Struthers Ranch Subdivision Filing No. 5

Traffic Impact Study

LSC #204110
PCD File No. VR-2101

RE: Struthers Ranch Subdivision Filing No. 5
Traffic Impact Study
El Paso County, Colorado
LSC #204110

Exhibit 2
**Line of Sight for
 Intersection Sight Distance
 (Struthers Ranch Rd to/from the south)**

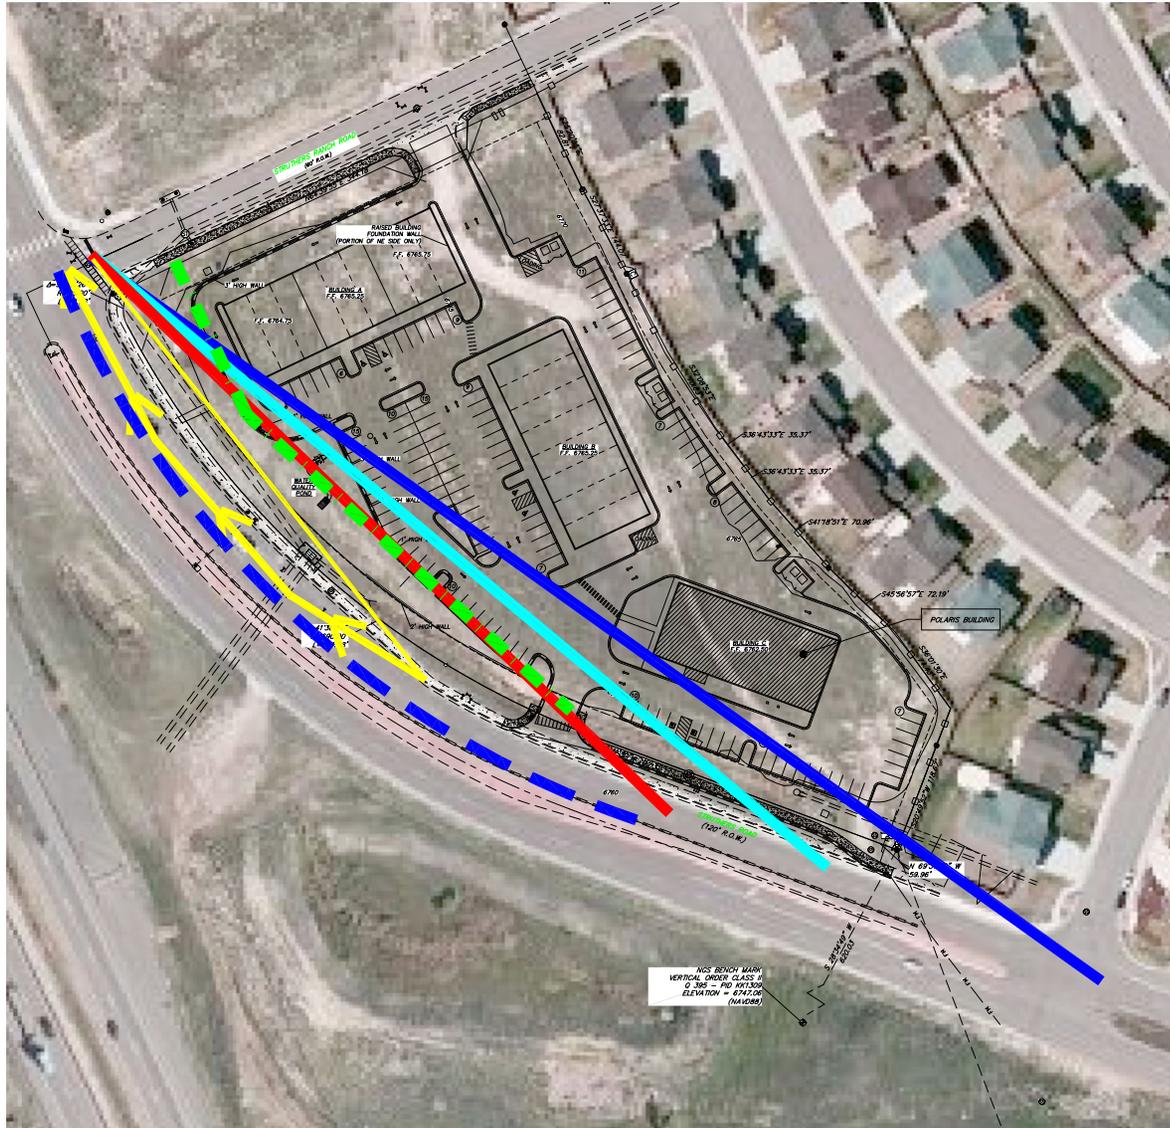
- Add the reference tables, charts, etc used.
- Provide the SSD computation in the appendix.
- State the vertex (decision point) in the minor road in measuring the line of sight from edge of travel lane.

Elaborate on the time gap used for the passenger car, single truck and combination truck.

Example: On the passenger vehicle the greenbook noted adding 0.5s for each additional lane crossed in excess of one. This would only result in 8.5 s (based on crossing one lane and the median lane). What is the reasoning for the additional 0.25 s

Also, identify the time gap used for the single unit truck.
